REQUEST

Current Zoning: R-3 (single family residential)
Proposed Zoning: R-8MF(CD) (multi-family residential, conditional)

Approximately 48.09 acres located south of North Tryon Street, east of Trevi Village Boulevard, and north of University City Boulevard.

The petition proposes to allow a residential community with 285 townhomes on a parcel of vacant land, located south of North Tryon Street and bordered by Cabarrus County to the east.

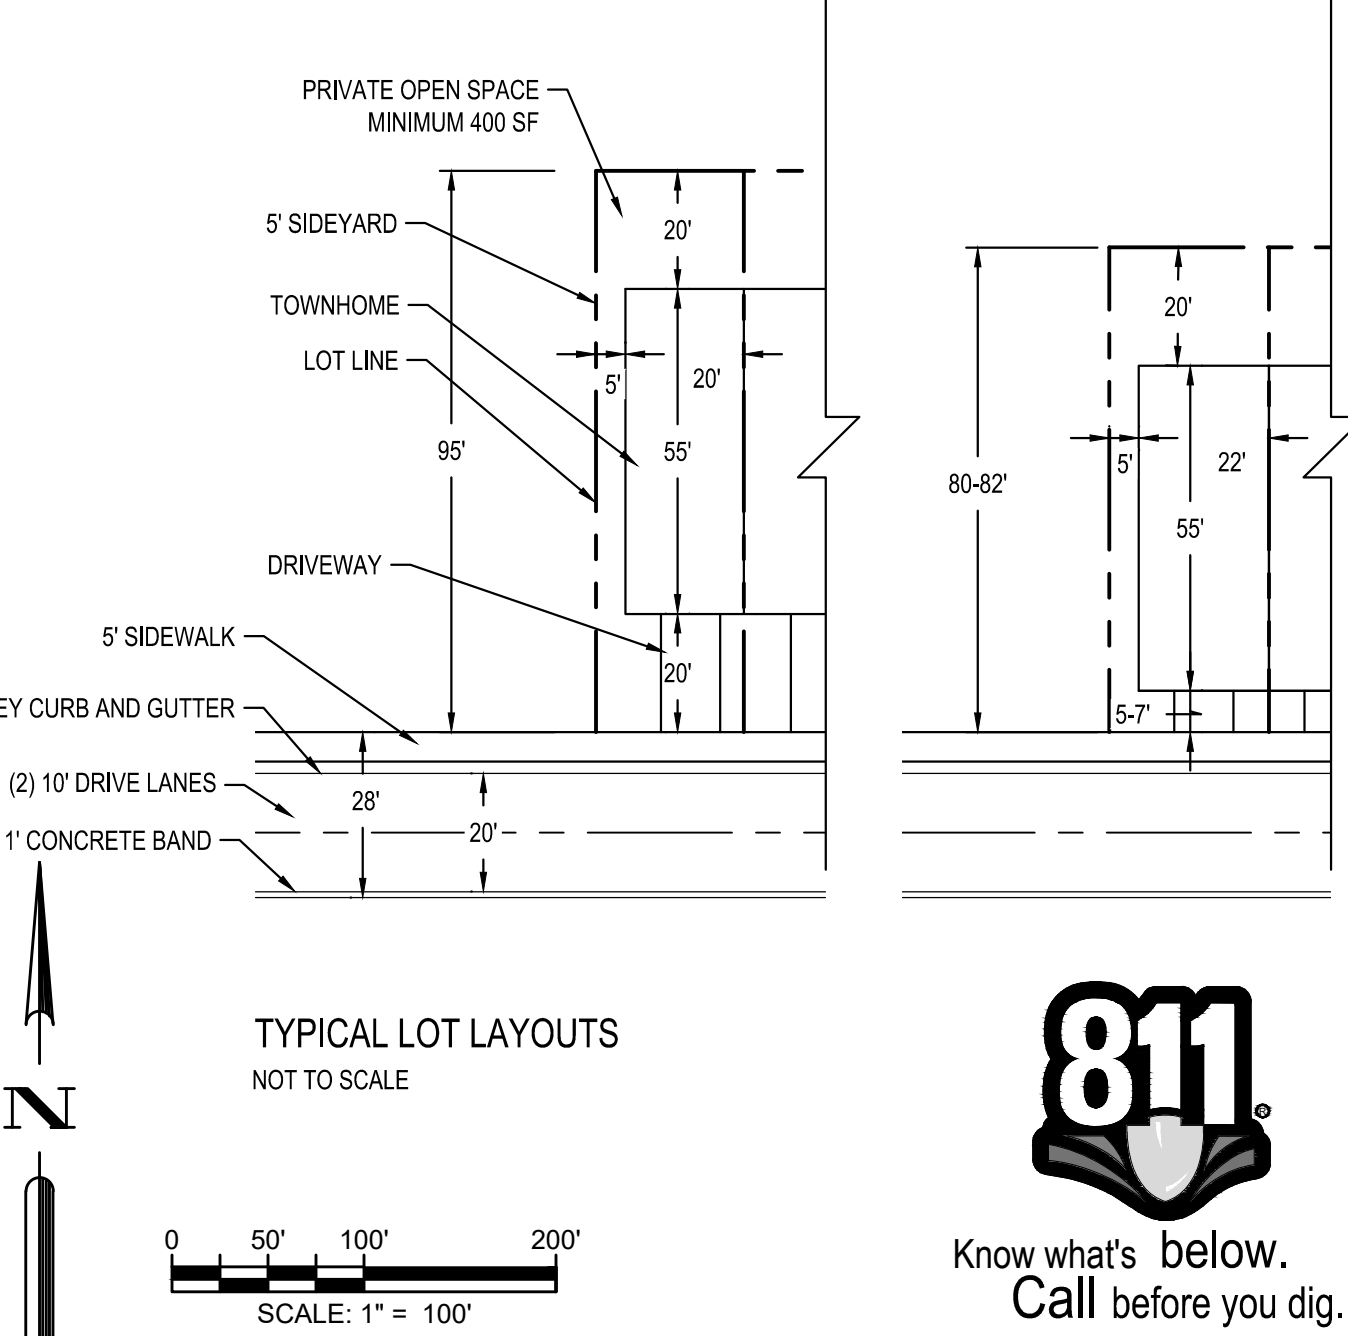
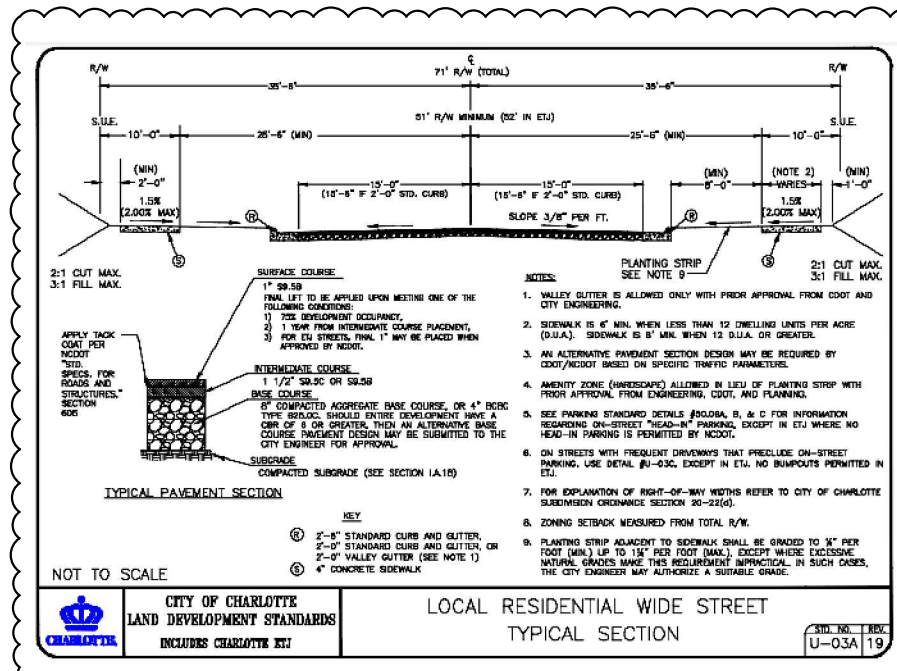
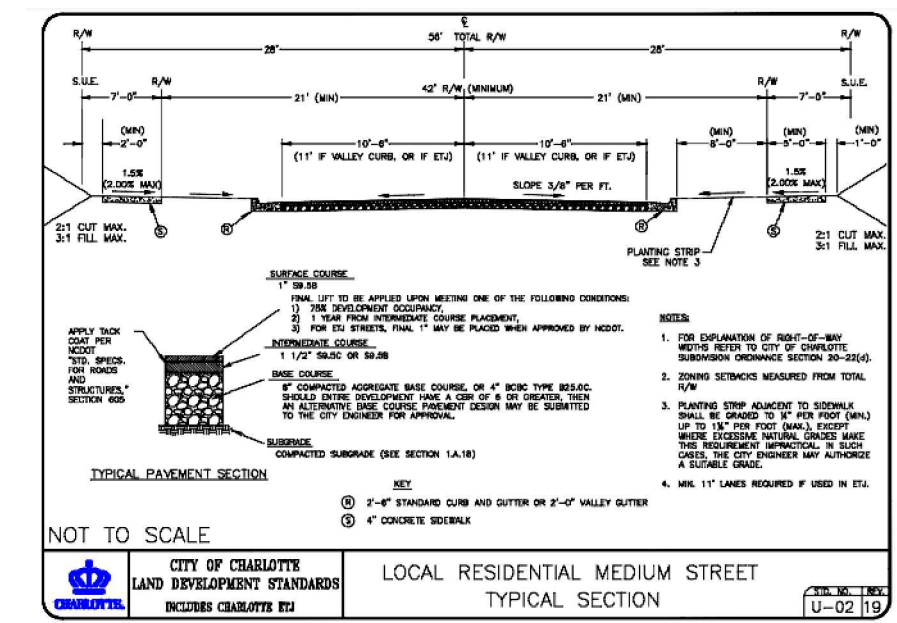
2. Amend labeling on Class C buffers illustrated on plan to state they may be reduced 25% with wall, fence or berm, not buffer, berm, or fence
